**ASCENT CHURCH  
Site Development Plan  
Letter of Intent**

PPR265

Ascent Church  
1750 Deer Creek Road  
Monument, CO 80132

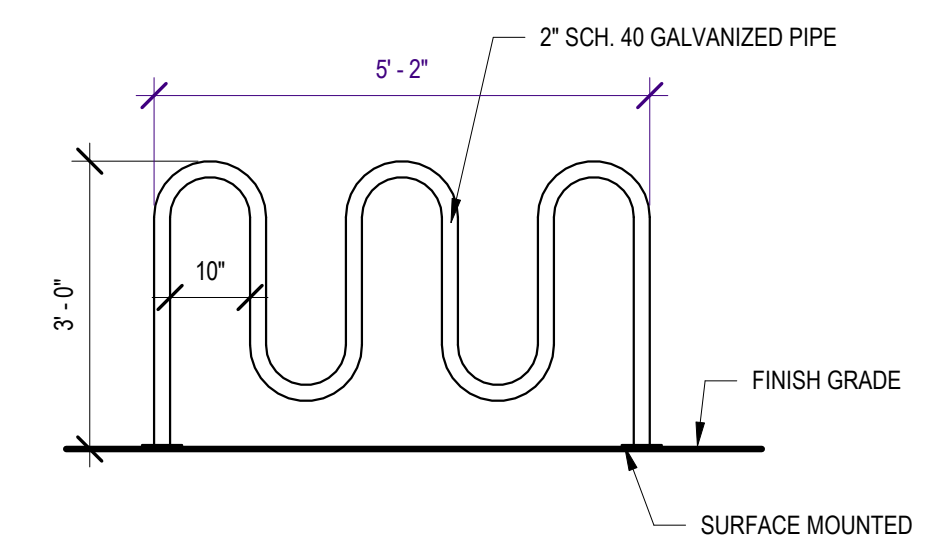
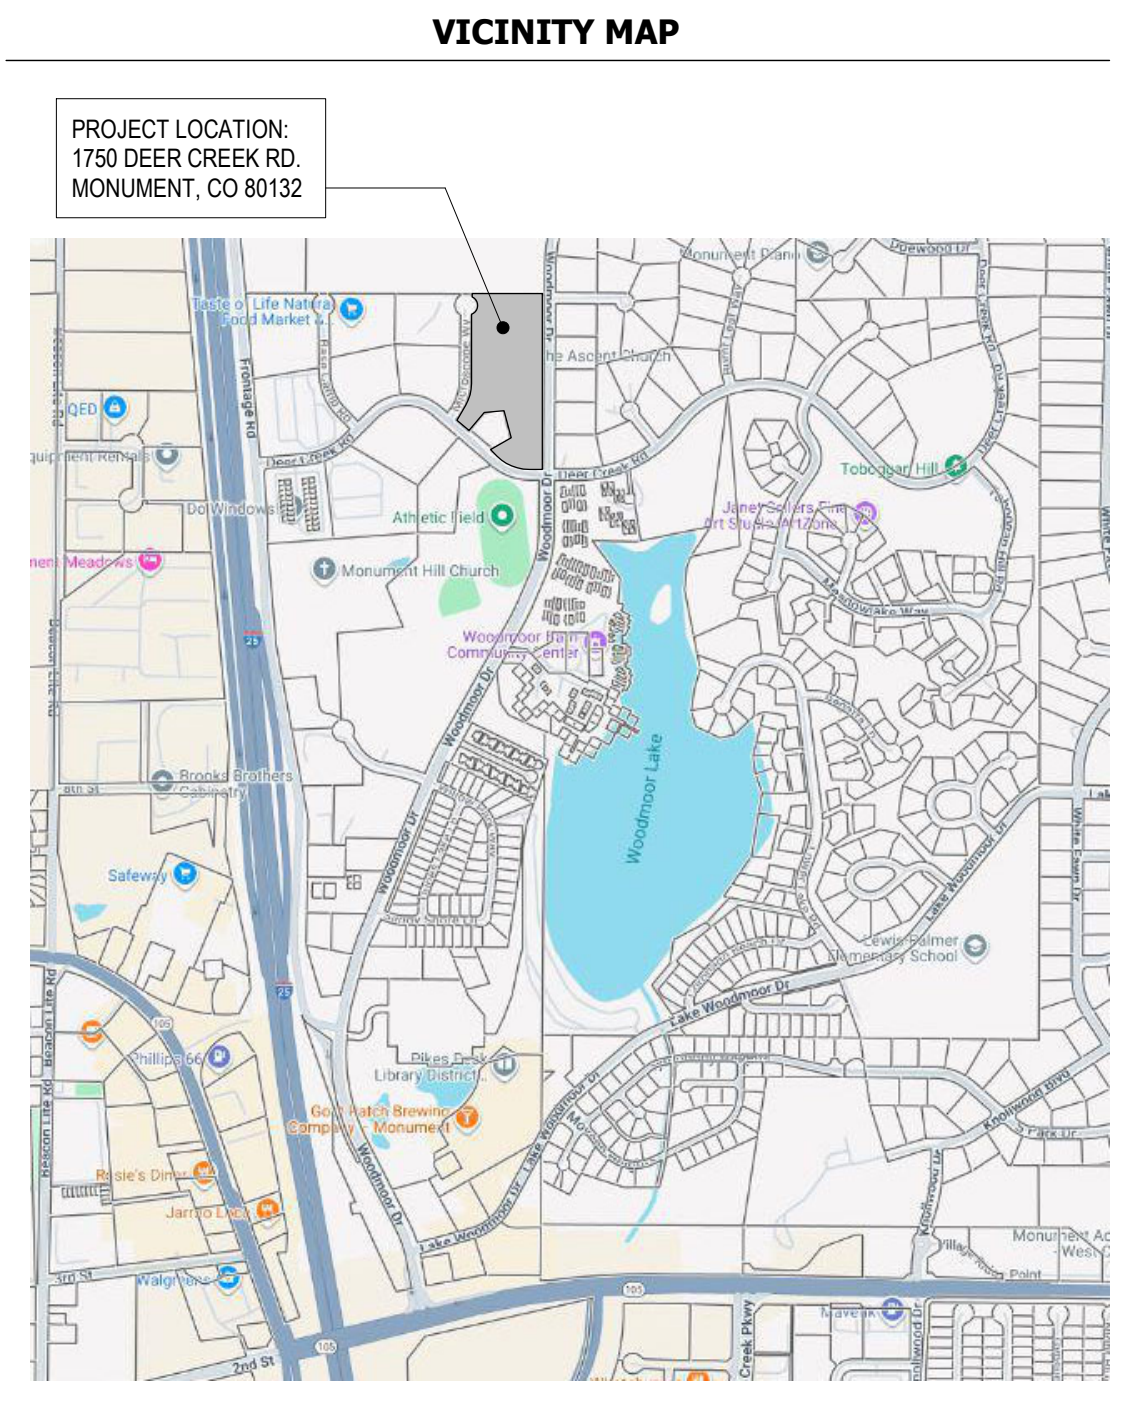
A substitute landscape design has not been identified. Provide detail of future improvements.

1 SITE PLAN & PARKING PLAN - LIGHTING / PARKING IMPROVEMENT

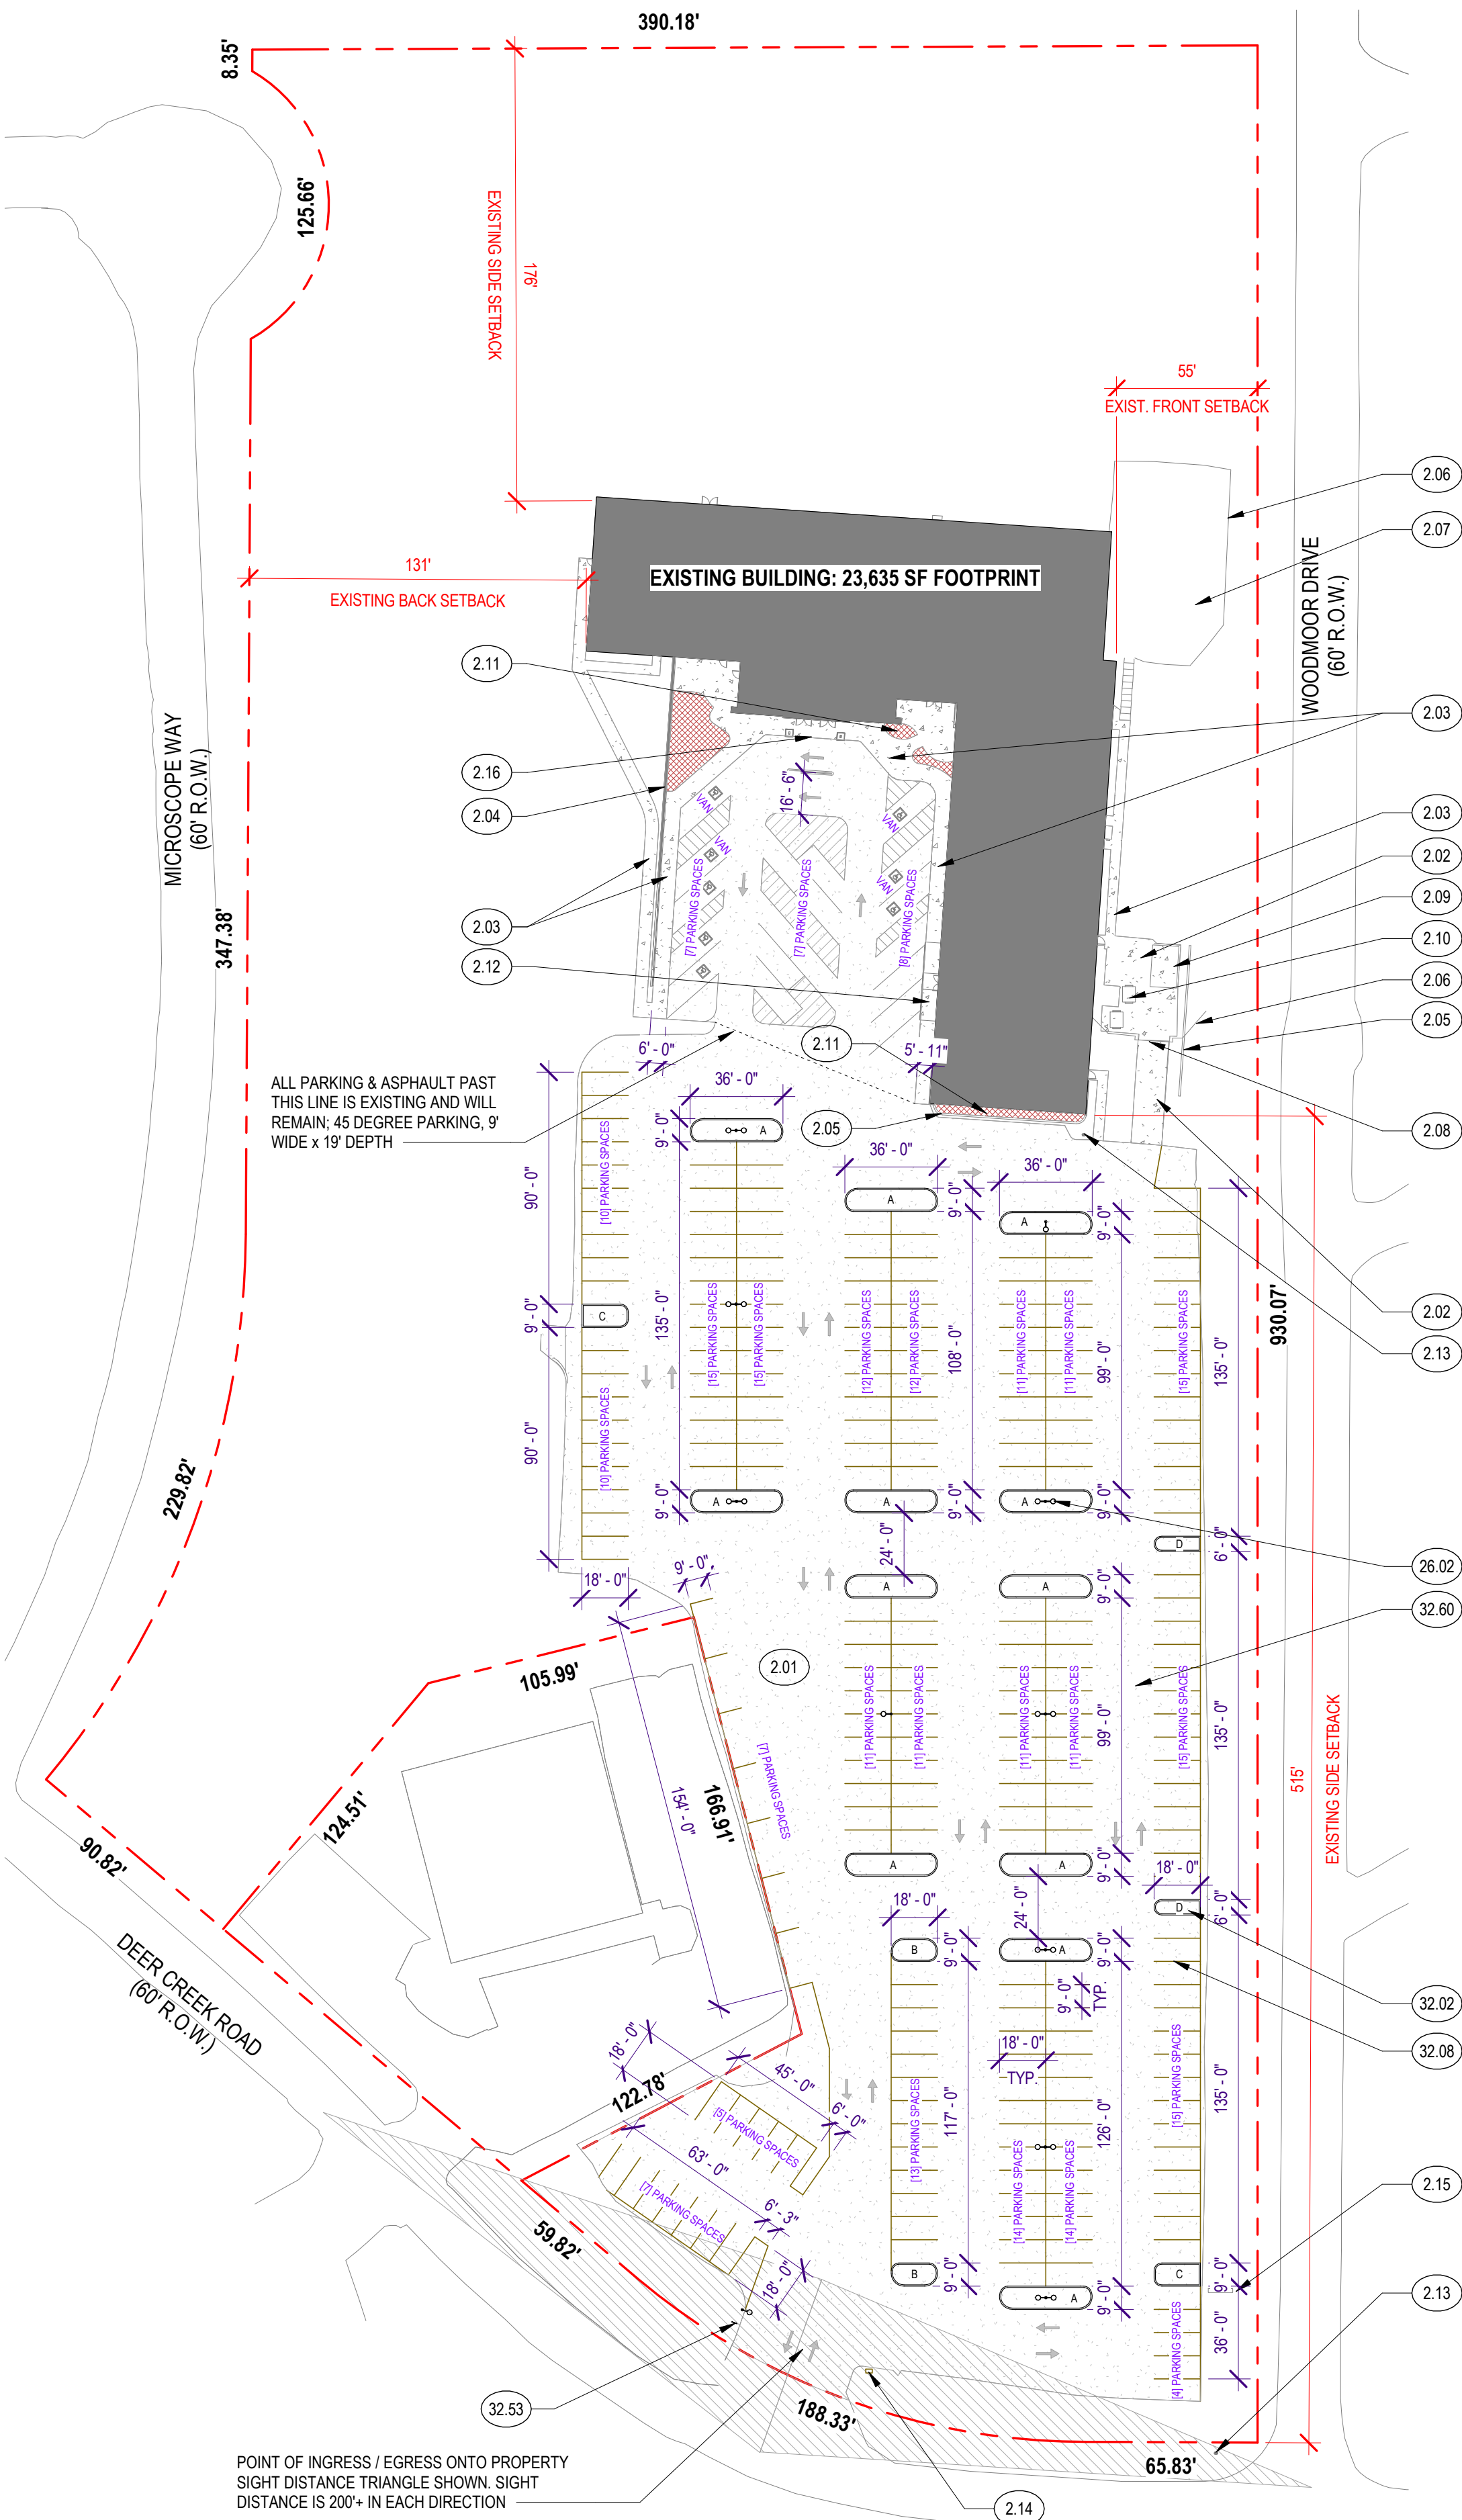
Parking lot lighting was not depicted on V2\_ documents. Provide detail of the future improvements.
